**From:** William Clark  
**To:** Jean Fraser  
**CC:** David Margolis-Pineo; Jennifer Thompson  
**Date:** 10/22/2015 2:22 PM  
**Subject:** Re: Fwd: 415 Subdivision Plat for PB - signoffs needed (2015-162) - Plan Needs Attention  
**Attachments:** Cumberland Ave No 415 Draft Plat 10.14.15 Survey Review 10 22 2015.PDF

**RE: The Capacity to Handle Wastewater Flows from 415 Cumberland Ave**

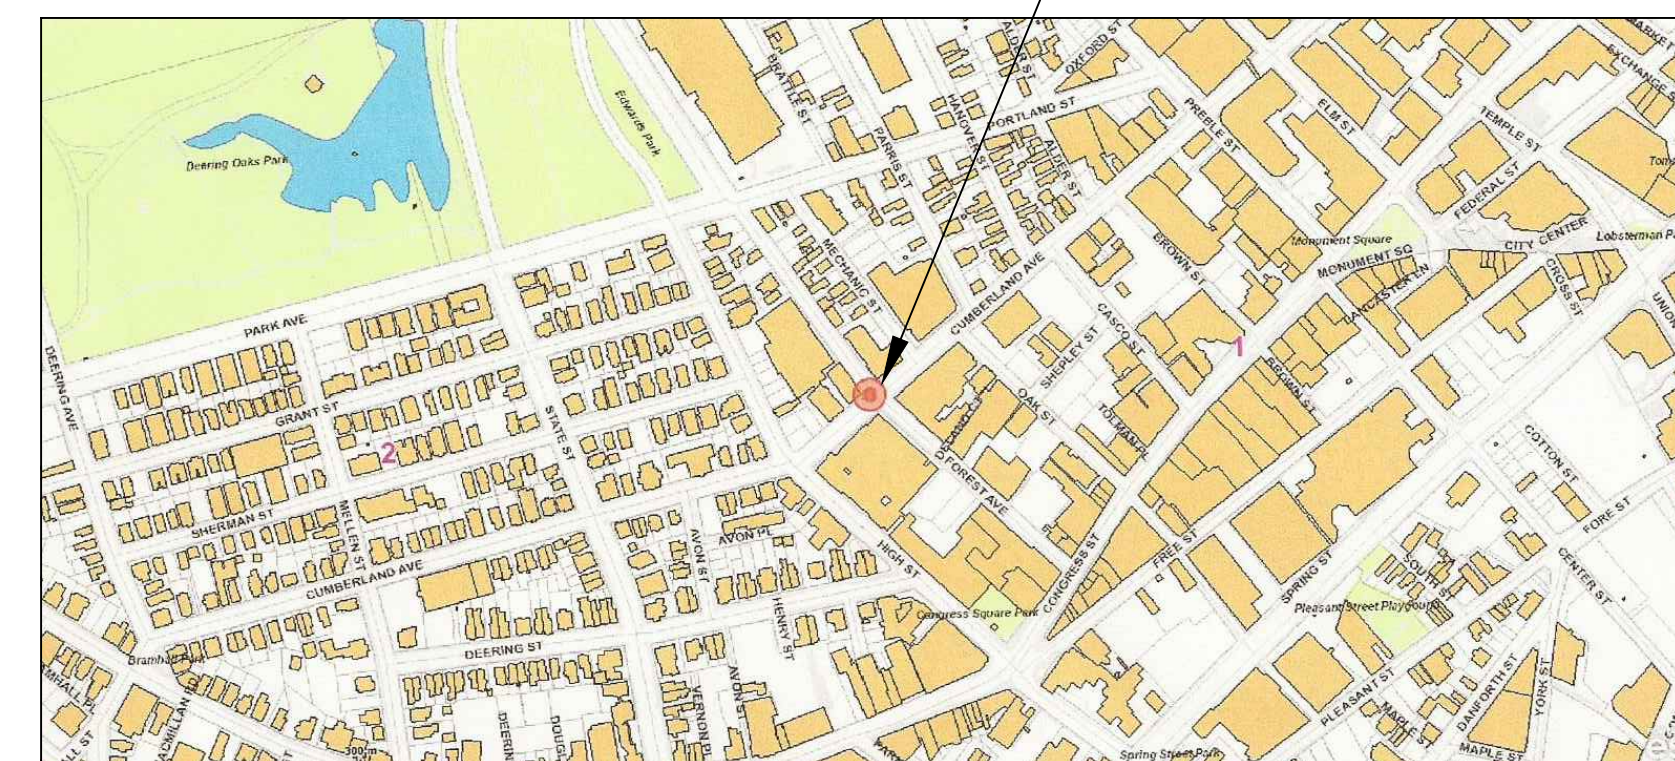
Examination of plan and deeds shows it needs attention and should not be approved. Plan review markup is attached. I am glad Jen made comments as to the easements.

1. Easements need to be correctly defined on the plan with bearings and distances. The easements were drafted in 1925 before the YMCA building was constructed, and need to reflect what is on the ground. The Condominium Association will need to have the easements defined and the nature of the easements stated.

2. Incorrect Easement Deed Reference. CCRD Deed Book 3019, Page 133 is for a Tax Lien Discharge in Cumberland , Maine.
3. Text "Existing Easement Area book 1212, Page 217" points to the easement area for easement in Deed Book 1212, Page 215.

4. Coordinates are not correct for the two points listed along Forest Ave.
5. Elevations are not correct for the two points listed along Forest Ave.
6. Need to set property corners.

7. Coordinate System. NAD83?  
The City of Portland coordinate system is NAD83 HARN Maine State Plane: West Zone (FIPS 1802) US Survey Feet
8. Vertical Datum. Which City of Portland official benchmark was used?

9. "Lotus Map". I believe this should be "Locus Map".
